Our ref: PA01138205

18 December 2020

Pre-application Advice

MONKS HALL, SYLEHAM, SUFFOLK

DRAWING
 Existing Second Floor Plan

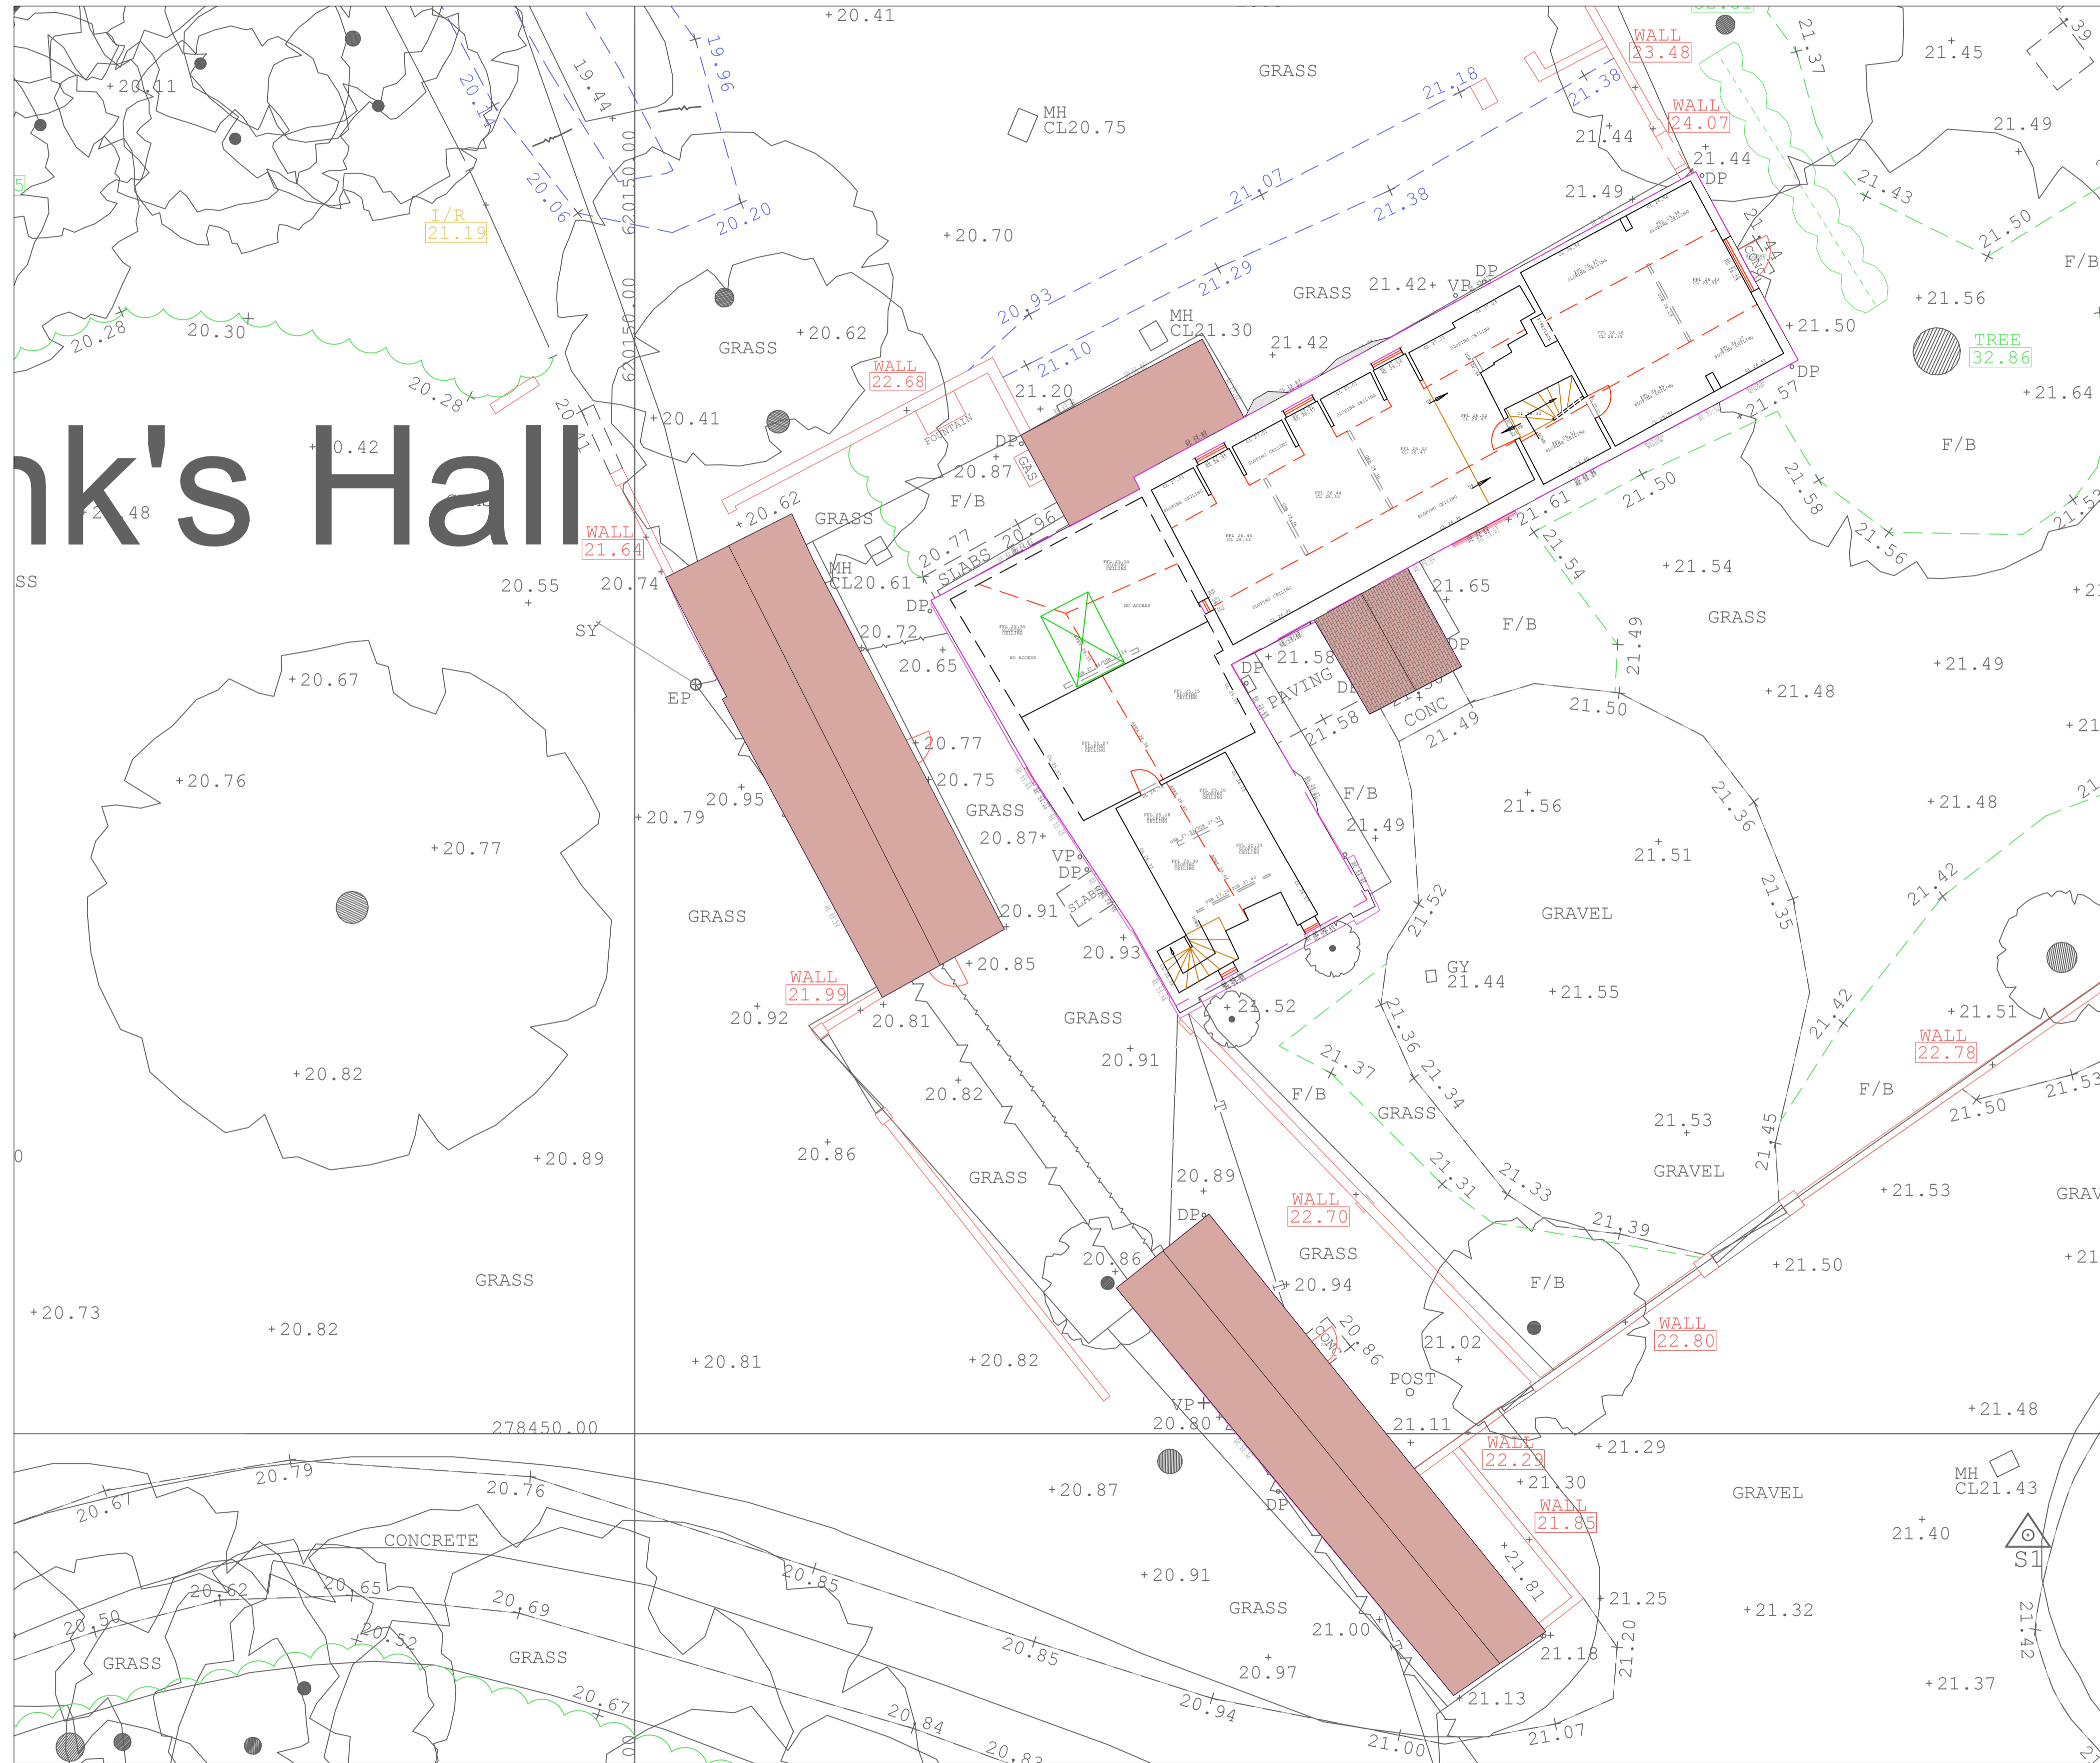
From a brief look at the plans provided there seems to be bathrooms inserted on every floor. On the second floor there seems to be some further subdivision through the insertion of more stud walls which are subject to the same concerns as above. As with all of the new bathrooms throughout the building, we need to be certain whether new vents, ducts, flues and extractors are required and whether the floor is able to take the weight of the bathroom equipment.

Both the first and second floor contain feature walls in bedroom suits that are in the centre of rooms and partition the spaces, even if they are not full width or full height. Although it may be desirable to demarcate space and provide some private spaces within rooms, they also act to break up a room where the plan form of it may be important to the overall significance of the building. More understanding of the hierarchy of spaces and the importance of the plan form is required.

DRAWING
 Proposed Site Block Plan

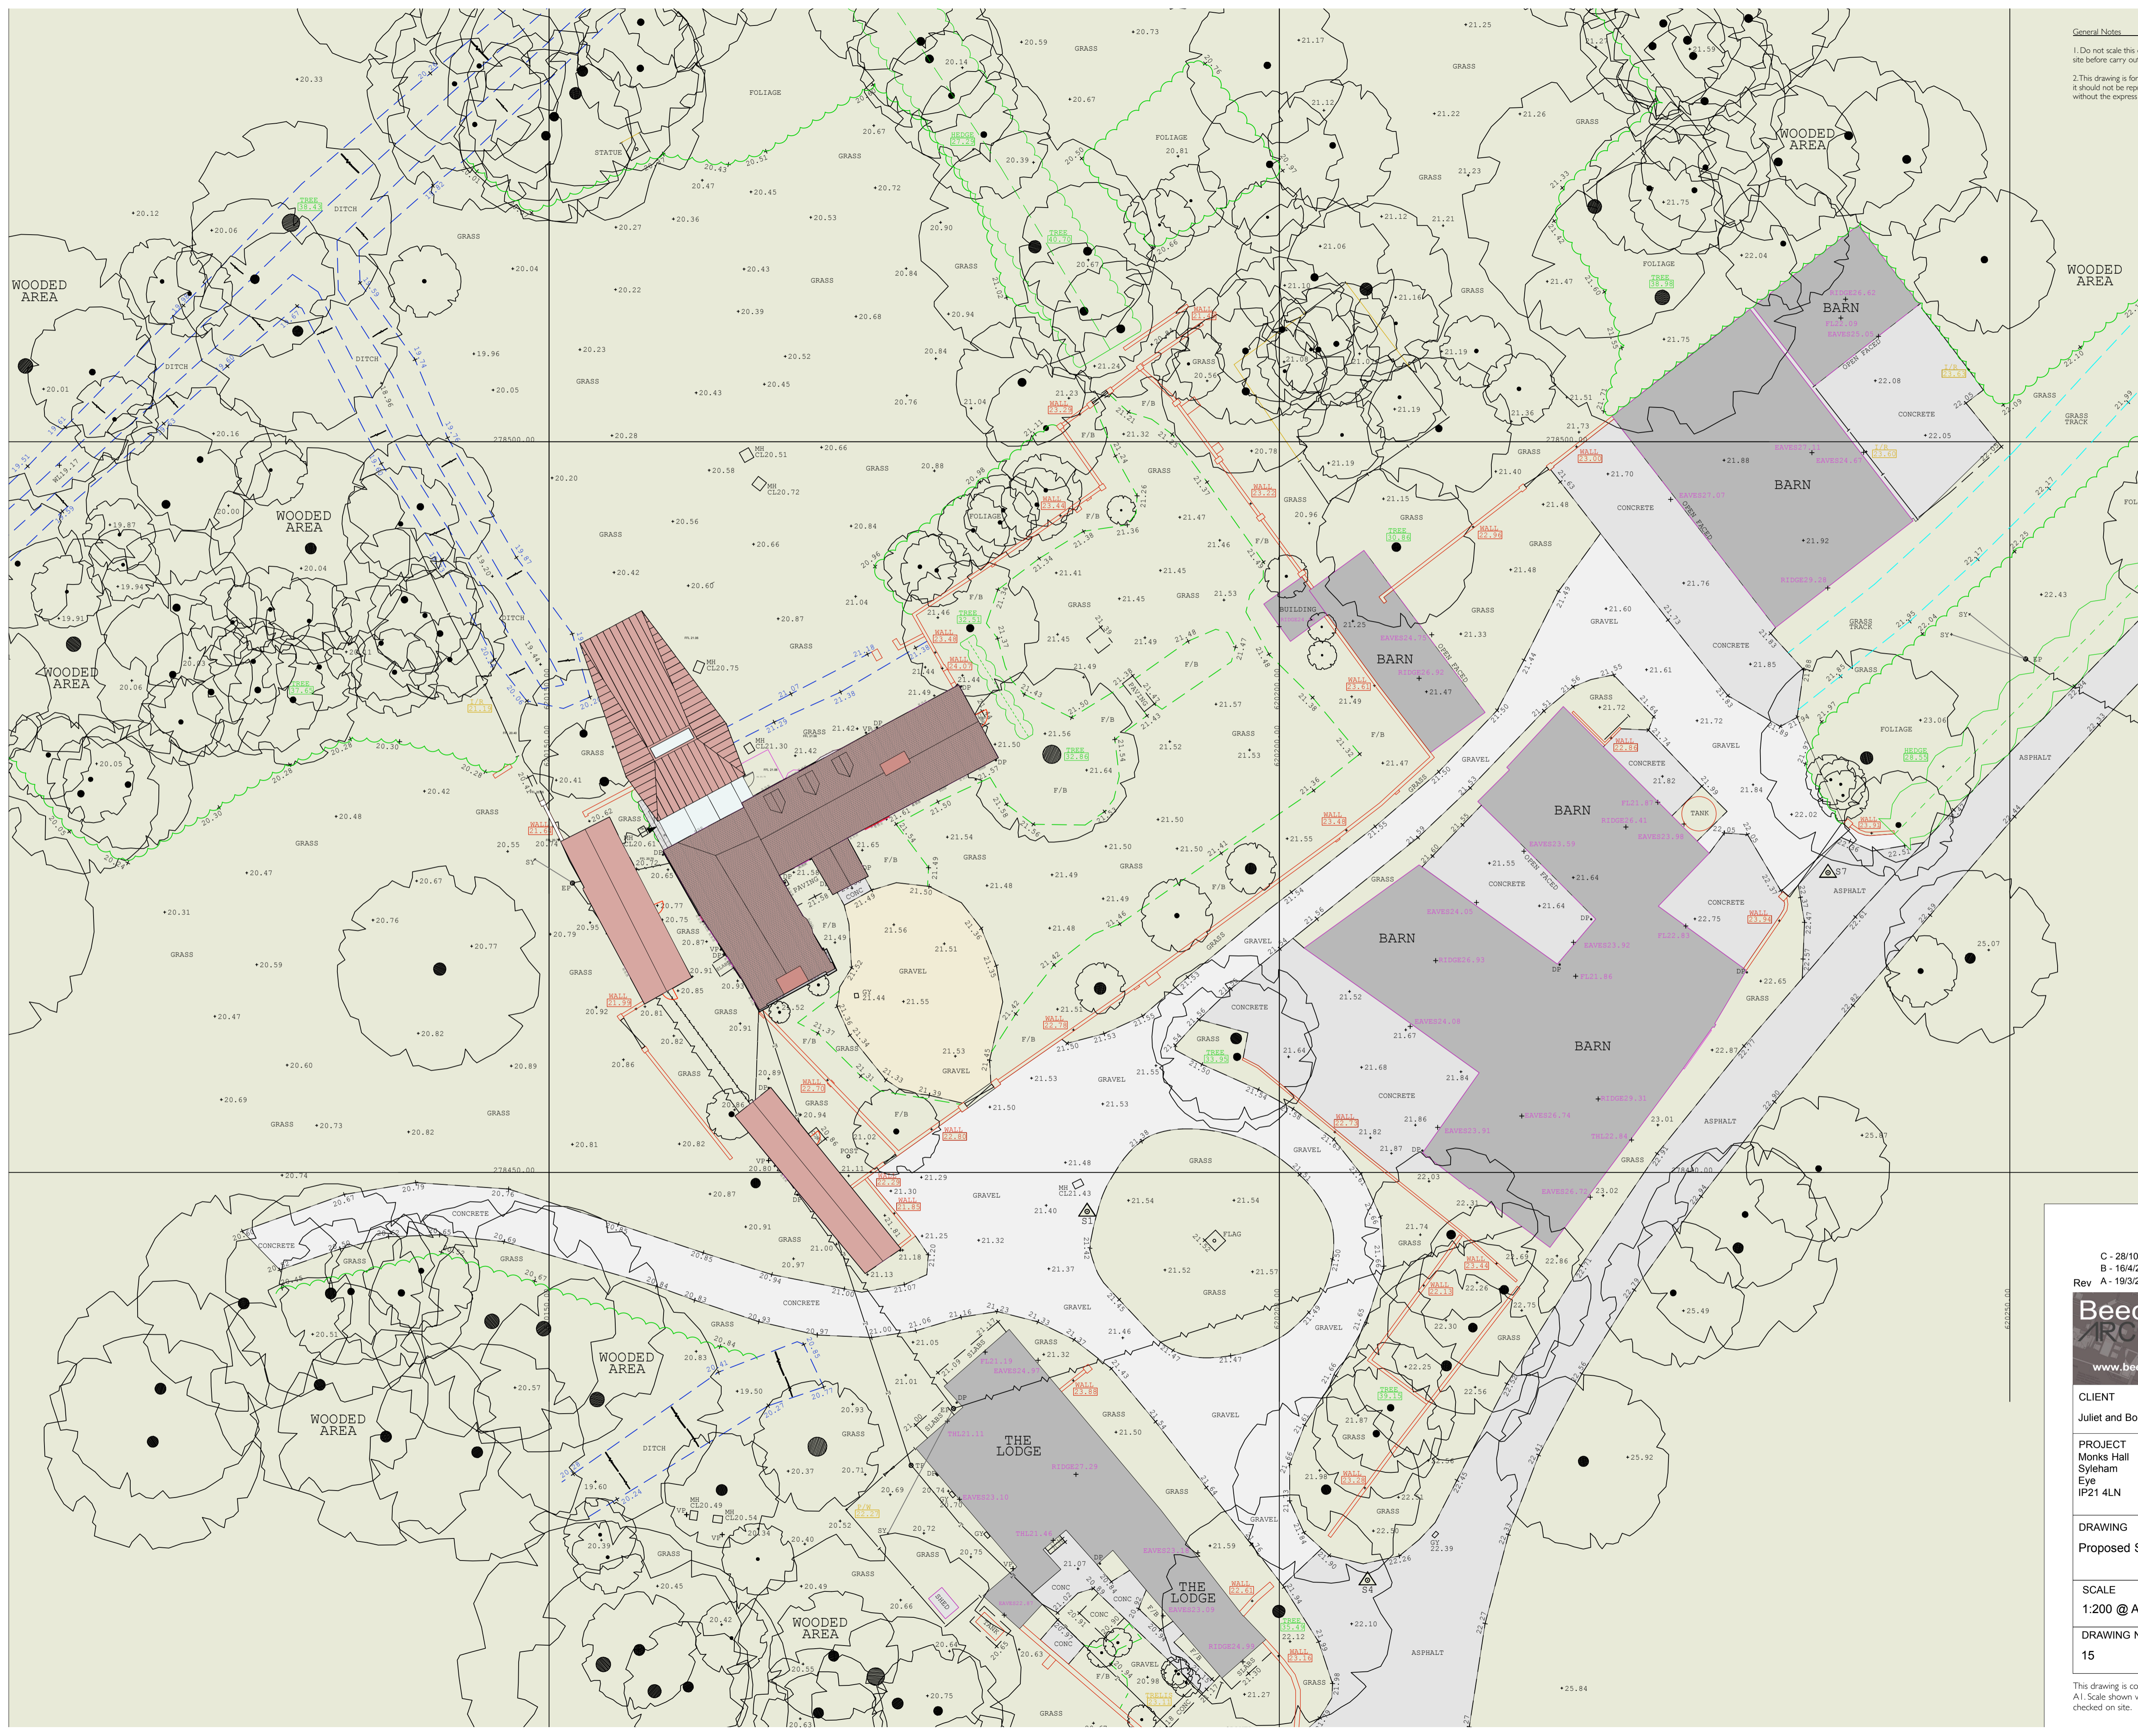
between the house and the 'pavillion' appears rather unnecessary and appears awkward against the main house. The link between the outbuilding and the house is less of a link and more part of the extension which makes it appear more dominant. Linking the outbuildings to the house is also questionable as historic maps indicate that these have always been separate and the significance of this is not discussed within the pre-application submission.

The additional hard surfaced terrace surrounding the extension gives the appearance of extending the built form into what has historically been a garden environment leading to the river and fields. Adding hard surfacing in this area, certainly to the extent proposed could be said to have a detrimental impact upon the setting of the grade II* listed building.
